SECTION 4.55(1A) MODIFICATION APPLICATION Sydney Metro Martin Place Station Precinct – North Site (SSD 9270) MOD 5

This application has been prepared by Ethos Urban on behalf of Macquarie Corporate Holdings Pty Ltd, pursuant to Section 4.55(1A) of the *Environmental Planning and Assessment Act 1979* (EP&A Act) to modify SSDA 9270 relating to 50 Martin Place, 9-19 Elizabeth Street, 8-12 Castlereagh Street, 5 Elizabeth Street, 7 Elizabeth Street, and 55 Hunter Street (North Site), above the northern entrance of the new Martin Place Metro Station.

**CSWSMP-MAC-SMN-AT-DRG-DA-302900**

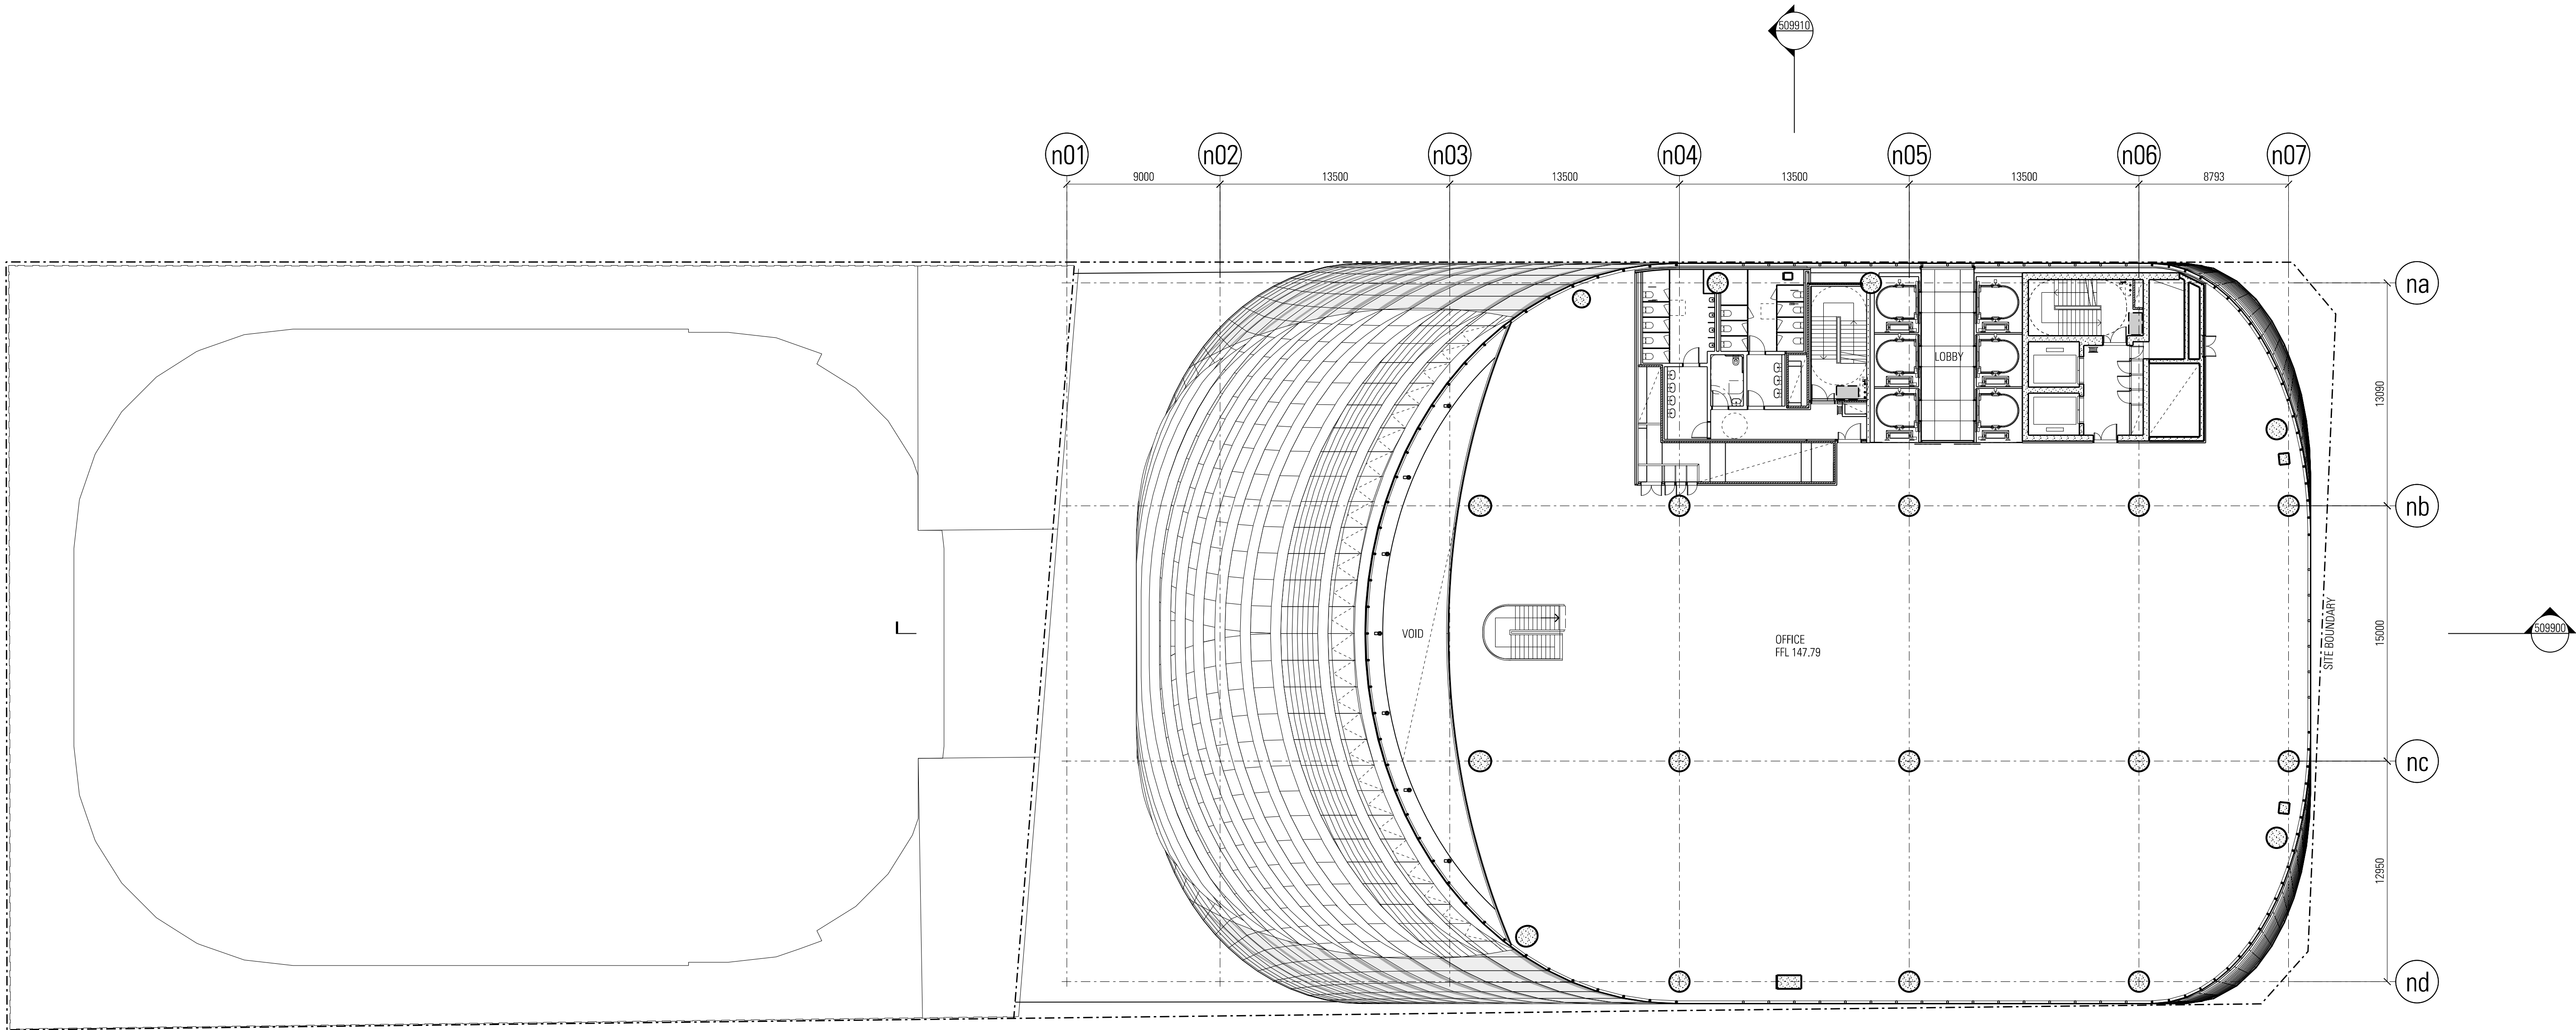
The approved high rise floors incorporate amenities and services within the western core block. Since approval, Macquarie have developed the high rise building design and servicing has been rationalised to reduce the extent of the core to the south-west and north-west. As such, the amenities and services have been relocated away from the south west façade to stack vertically from Level 29-37 and achieve more consistent workplace floor plates across the levels. The changes are contained entirely within the proposed building, and as such will not have any impact on the built form as previously approved. The re-arrangement will lead to a minor total increase of 239m² GFA across levels 29-37. The proposed changes are typical of the evolving design development process and are considered an improvement to the approved development from a functionality and useability perspective.
